**KIRKLEES METROPOLITAN COUNCIL
INVESTMENT & REGENERATION SERVICE**

DELEGATED DECISION TO DETERMINE PLANNING APPLICATIONS

Reference No:	2022/62/93930/W
Site Address:	1, Huntsman's Close, Beaumont Park, Huddersfield, HD4 7BR
Description:	Erection of single storey rear and front extensions and mono pitched roof above garage, formation of balcony to rear, application of off-white render insulation cladding to all elevations and external alterations
Recommending Officer:	Luke Walstow

OFFICER REPORT

GROUND FLOOR PLAN AP
1 : 50

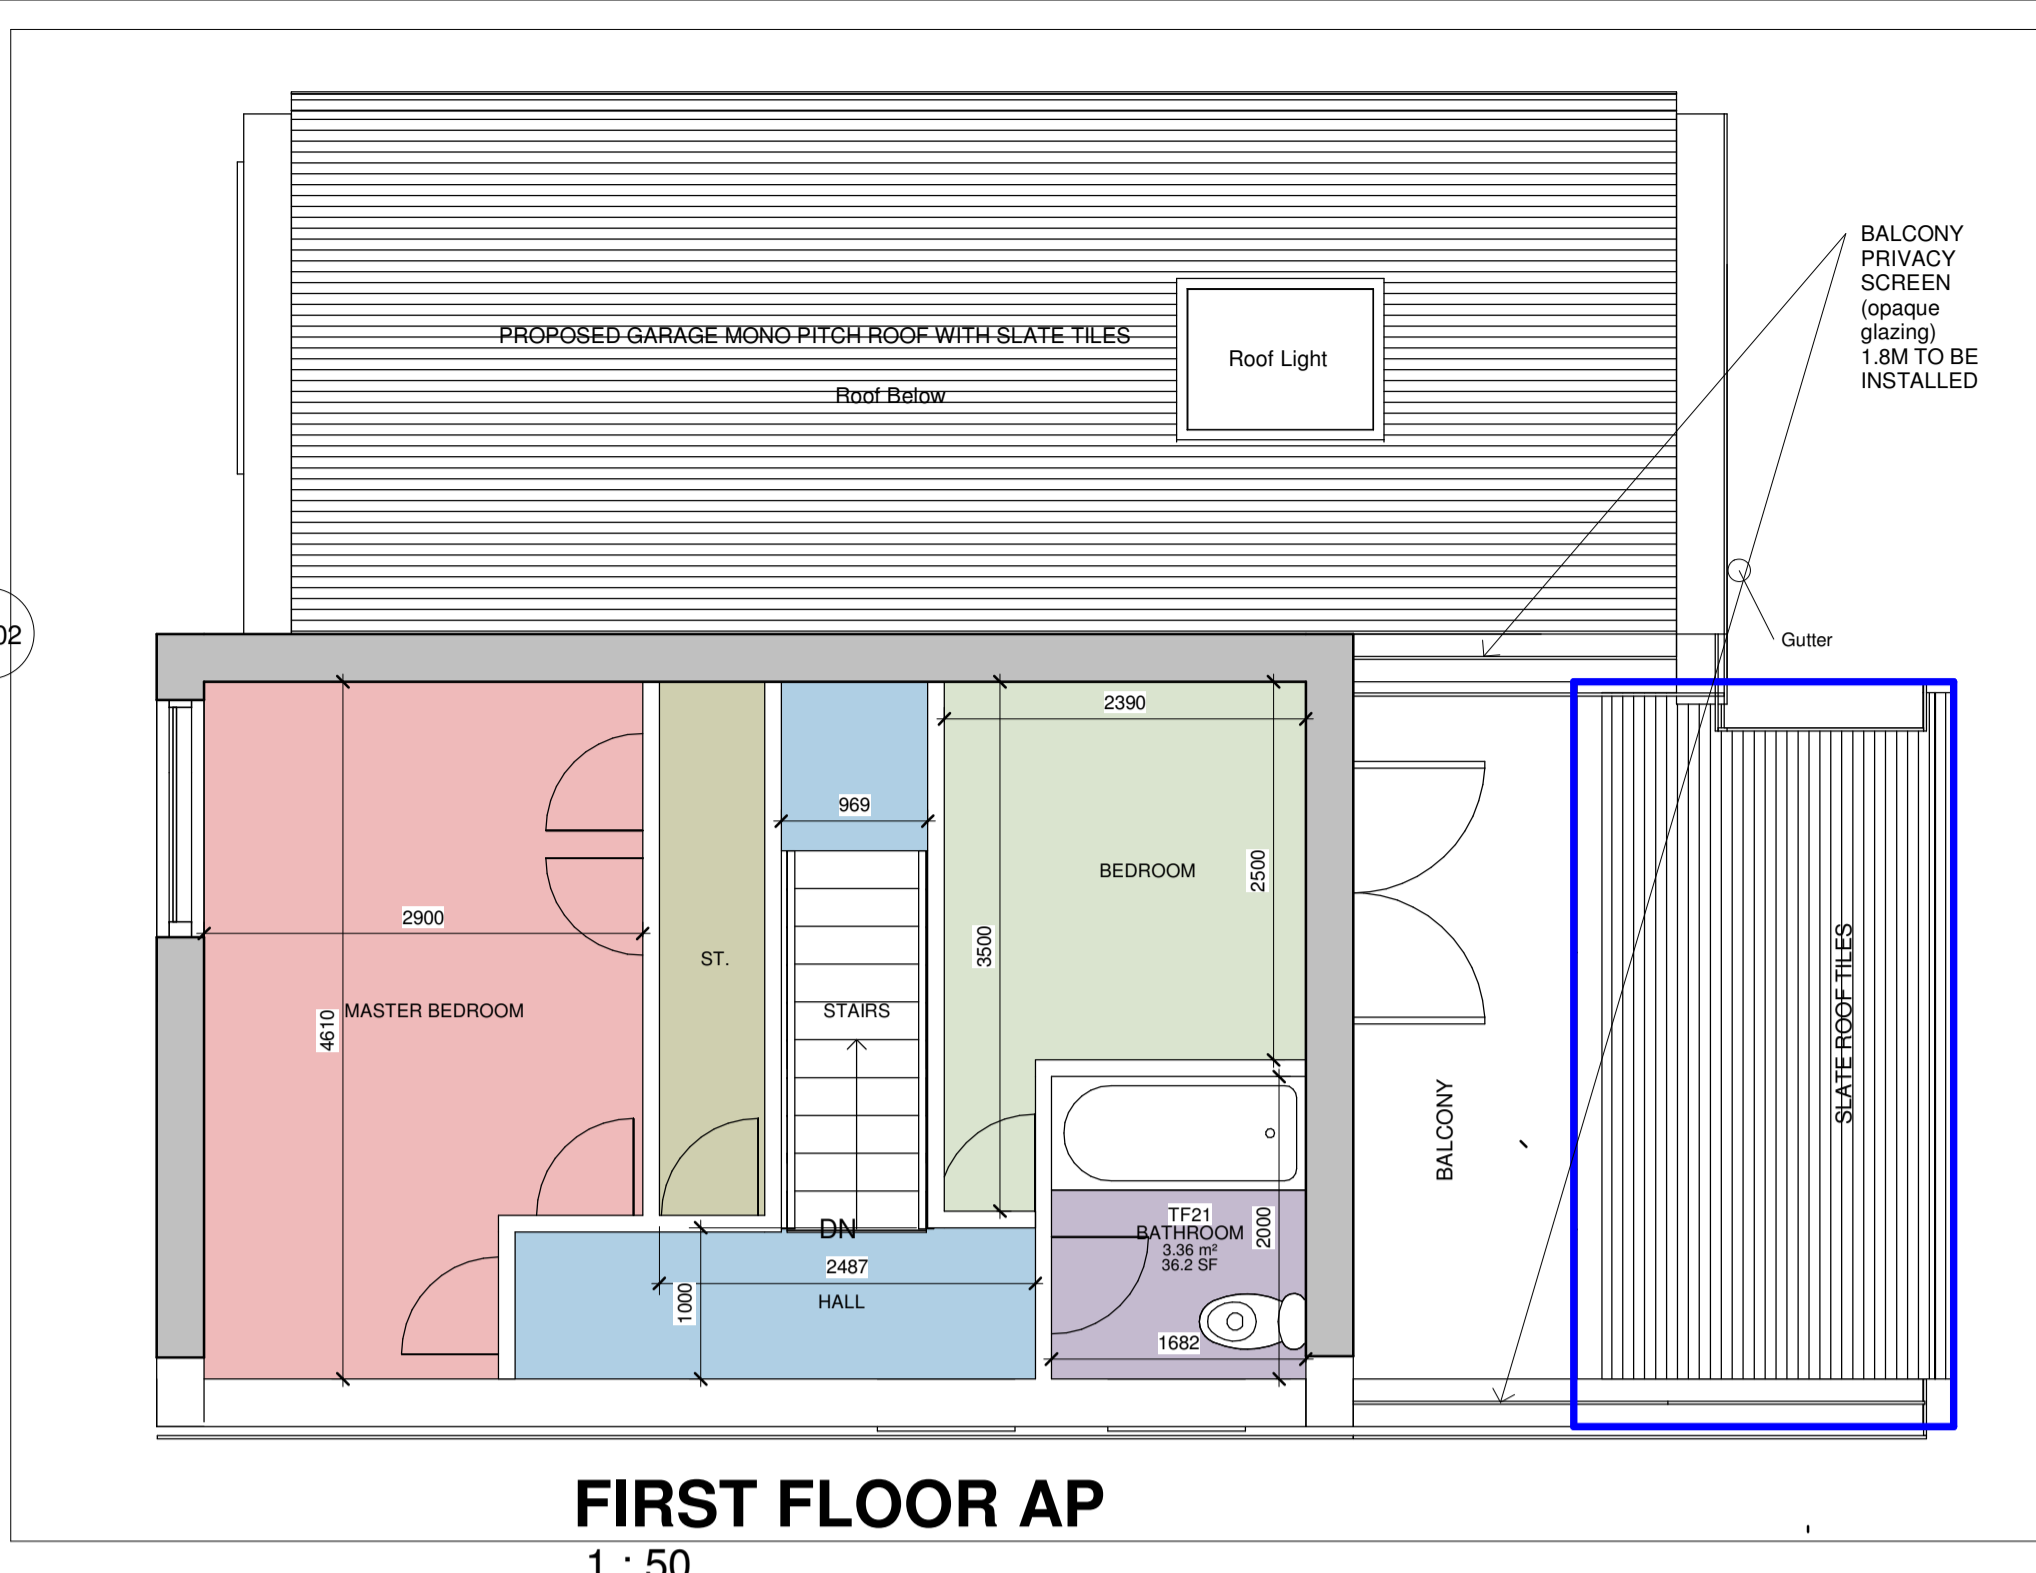
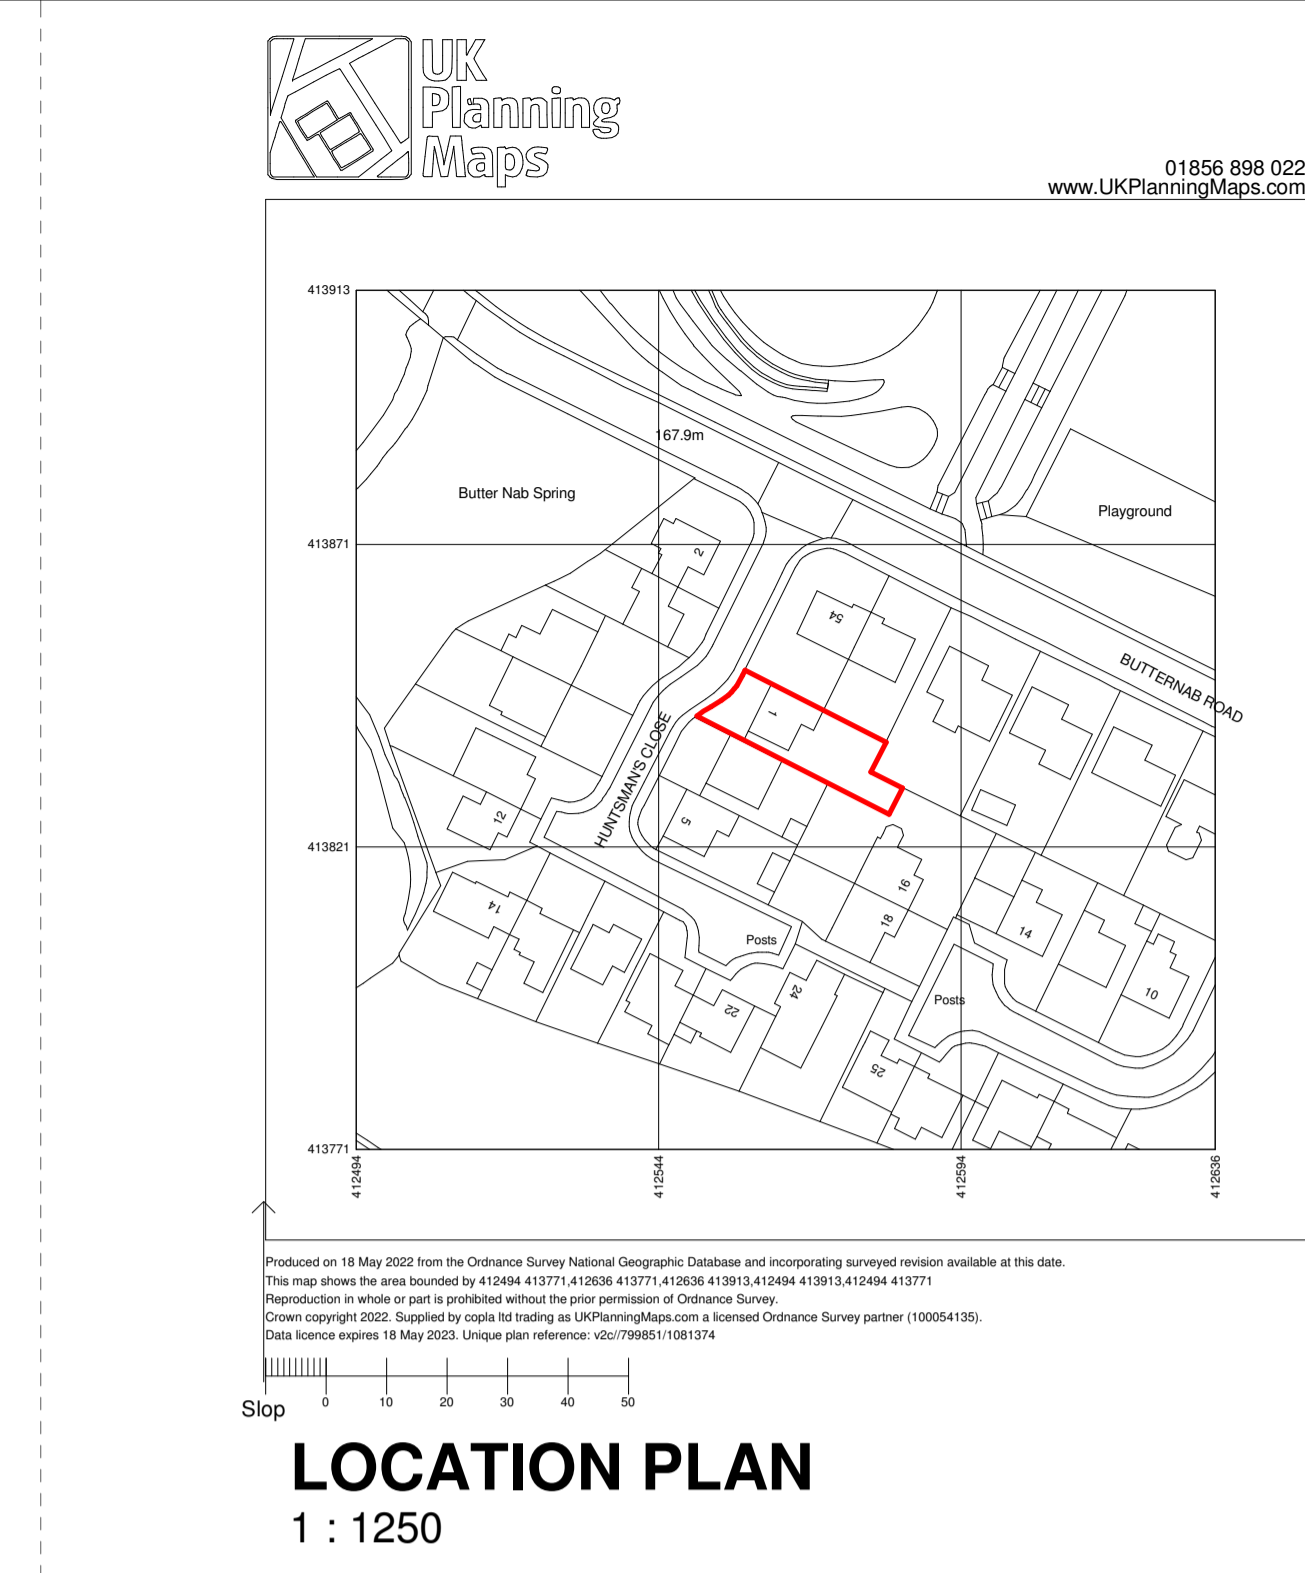
The balcony proposed will be located above the proposed rear extension, with access gained through one of the dwellings. The balcony will have views of the rear garden. Proposed 1.8m opaque screens are proposed to be installed on either side of the balcony to limit potential overlooking of neighbours' homes and gardens. In terms of design, the balcony is deemed acceptable by officers.

3 Huntsman's Close is the neighbouring property located to the South of the site. Concerns were raised by officers in relation to the balcony and overlooking of this property and private amenity space. Within amended plans submitted, the balcony has incorporated 1.8m high privacy screens on each side of the balcony made from opaque glass. This would limit the viewpoint from the balcony to an acceptable level in this case.

4. The development shall not be brought into use until the privacy screens detailed upon drawing P102RevP2 have been installed. The privacy screens shall be thereafter retained.
